From: Dusty Pilkington
Sent: Monday, March 25, 2019 11:43 AM
To: 'Cruse & Associates'
Subject: RE: BL-19-00001 Keunzli Survey Comments

Find attached comments on the survey. There are a couple of minor issues on the survey that came up in review, as listed in the PW memo.

SHEET 1 OF 2

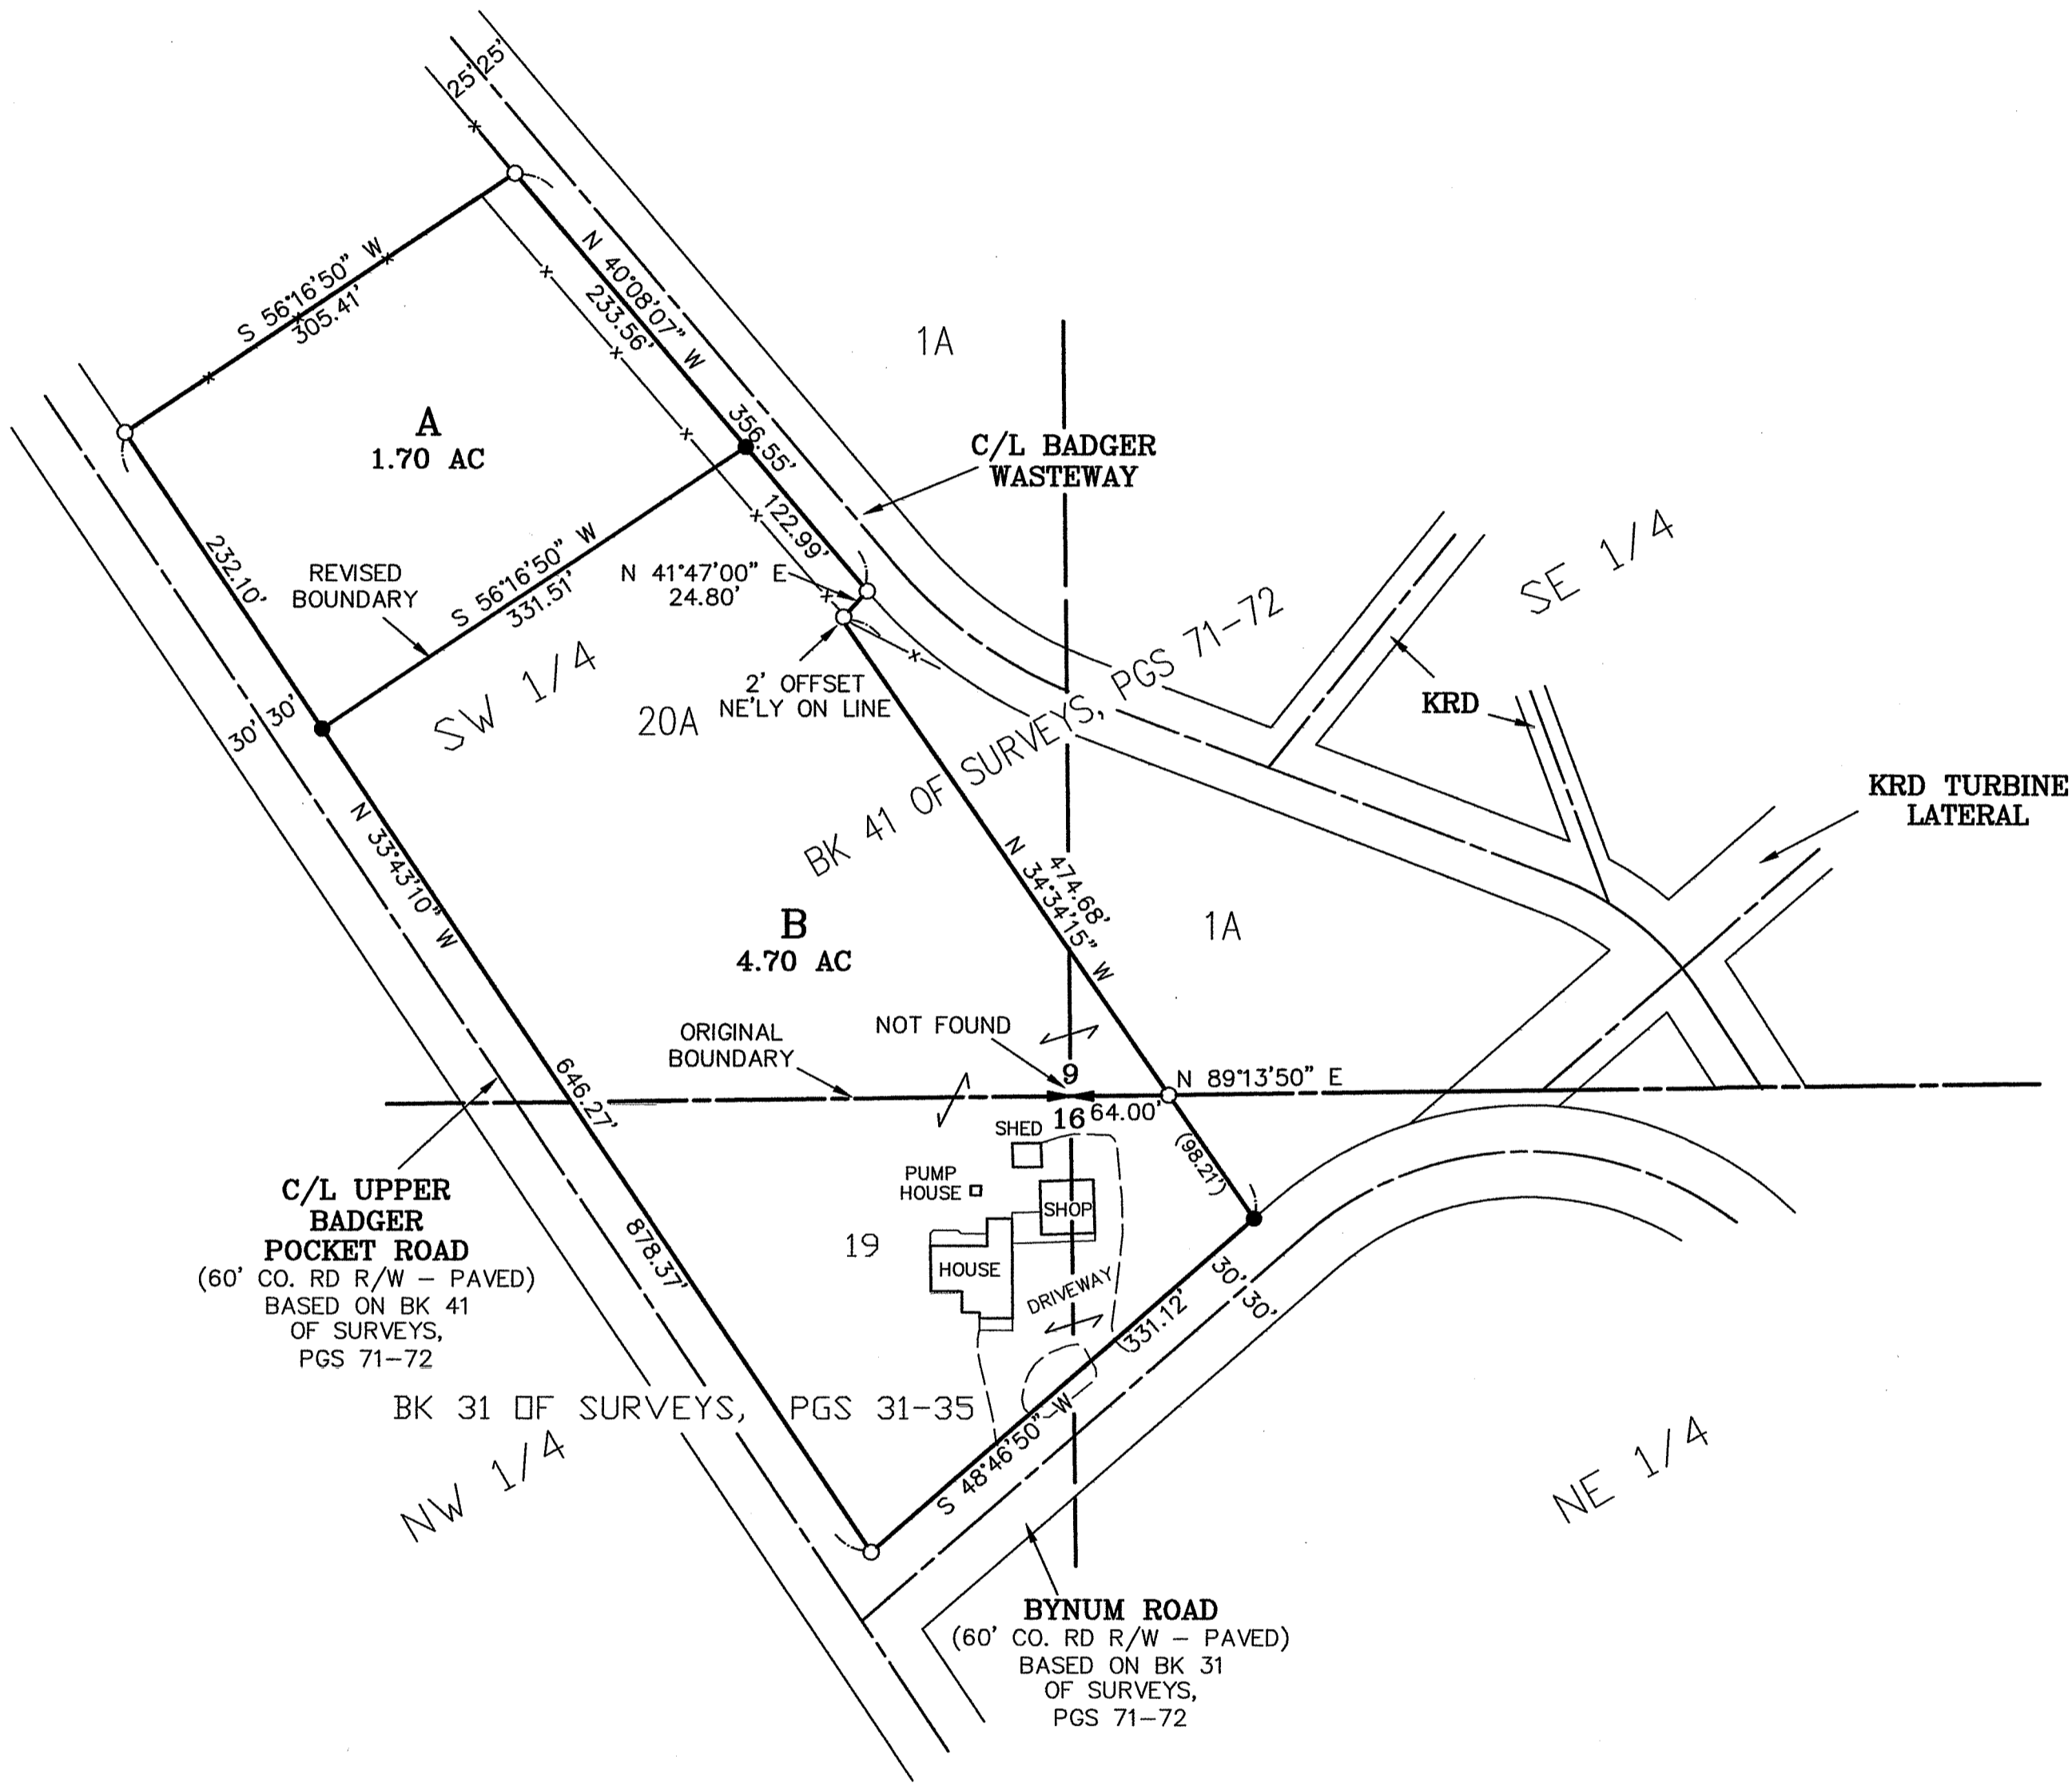
That is the case, with one caveat on my end. I am pretty sure you plan to address it prior to recording, but note number 3 is incomplete on the version I have. The irrigable acres numbers need to be filled in. As far as I can tell, it is good to record provided that issue is addressed, along with PW comments.
